From: David Margolis-Pineo
To: Barbara Barhydt; Jean Fraser
CC: DEVELOPMENT REVIEW GROUP
Date: 2/11/2016 1:57 PM
Subject: Review comments for 1363 Washington ave. - Taco Bell

Memo To: Jean Fraser
Barbara Barhydt
From: David Margolis-Pineo
Re: Development Review Comments for 1363 Washington Ave – Taco Bell

**Existing Conditions Plan of Land**

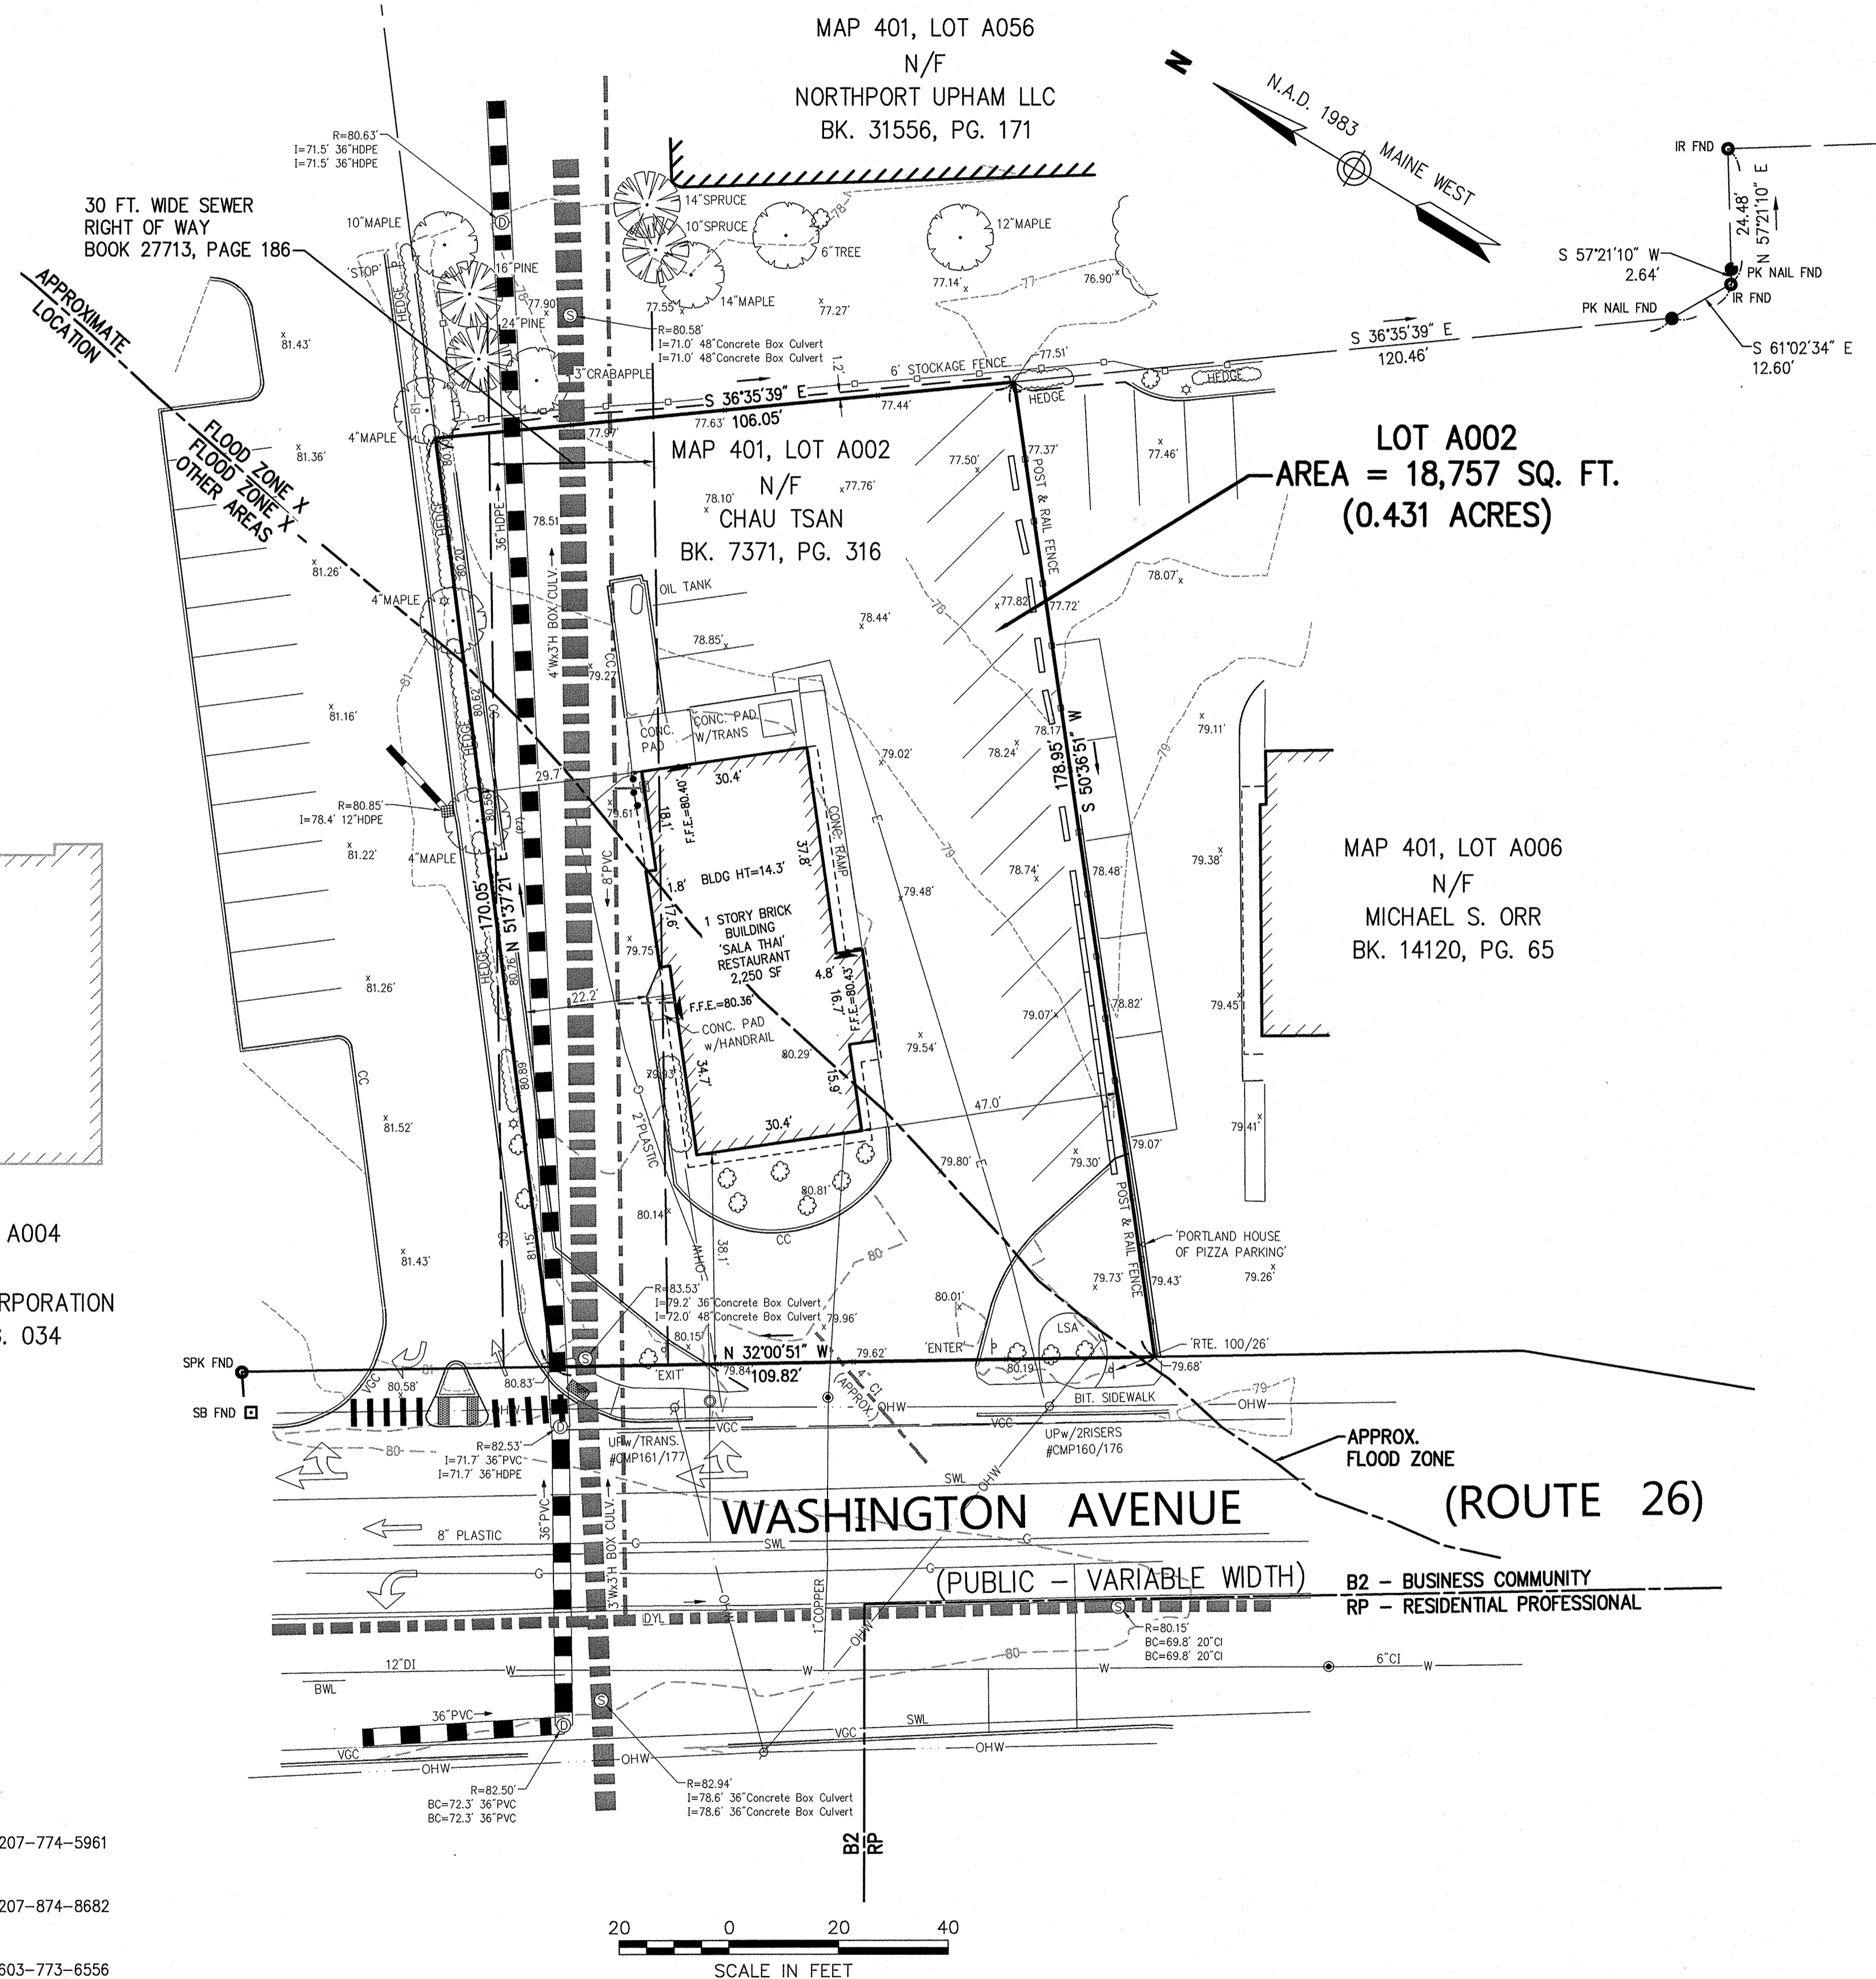
1. The sewer infrastructure which encroaches this site is shown incorrectly on the applicant's plans. Please correct and update the site's existing conditions plan to reflect current site conditions.
